Application No: FG/120/21/A
Site Address: Yeomans Peugeot Littlehampton Road Ferring BN12 6PB
Description of works: Installation of 2 x internally illuminated fascia signs and 1 x internally illuminated pylon sign

Thank you for your internet representation made on 28th July 2021 which has been recorded as an objection with the comments as follows:

PEUGEOT - Worthing, Yeomans (UK)
(Pylon)

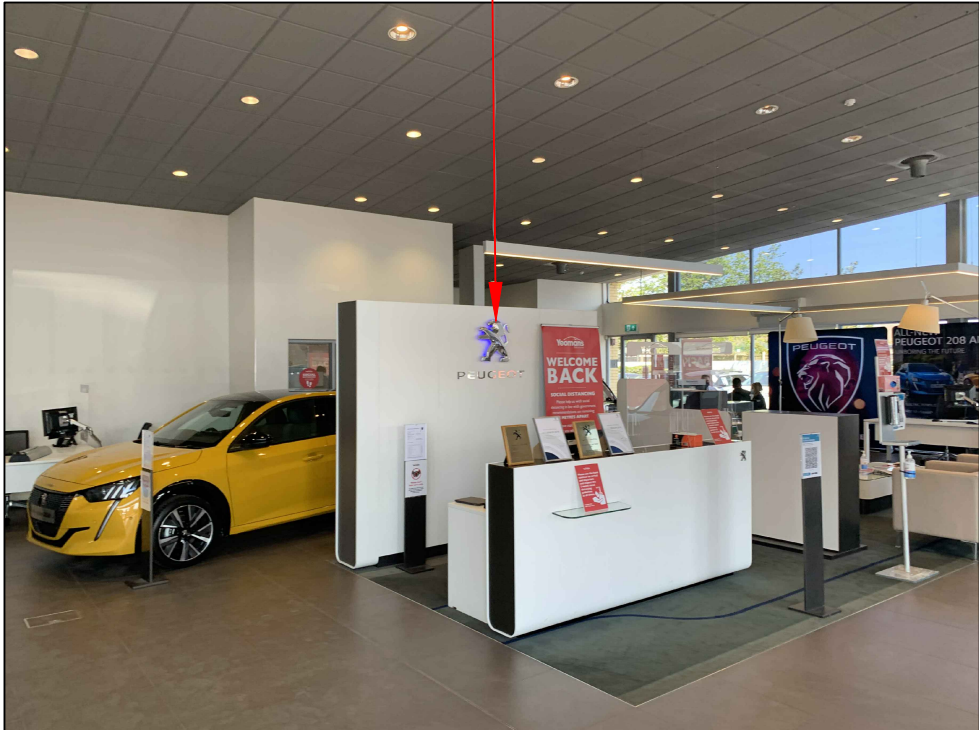
Ferring Parish Council objects to any increase in size of signage over that already permitted. The proposed increase in size of the totem is unjustified and will only serve to further add to the visual mass of signage in this location. This is directly on the roadside, highly visible and there is no reasonable requirement for any increase in dimensions.

Consideration must also be given to any increase in light pollution from all signage on the site, located at the base of Highdown Hill and the boundary of the National Park. It is noted that the proposed totem is to have internal lighting to current standards which we trust officers will ensure delivers a reduction in light pollution over the existing totem, especially when the dimensions are reduced to not exceed the currently permitted height and width.
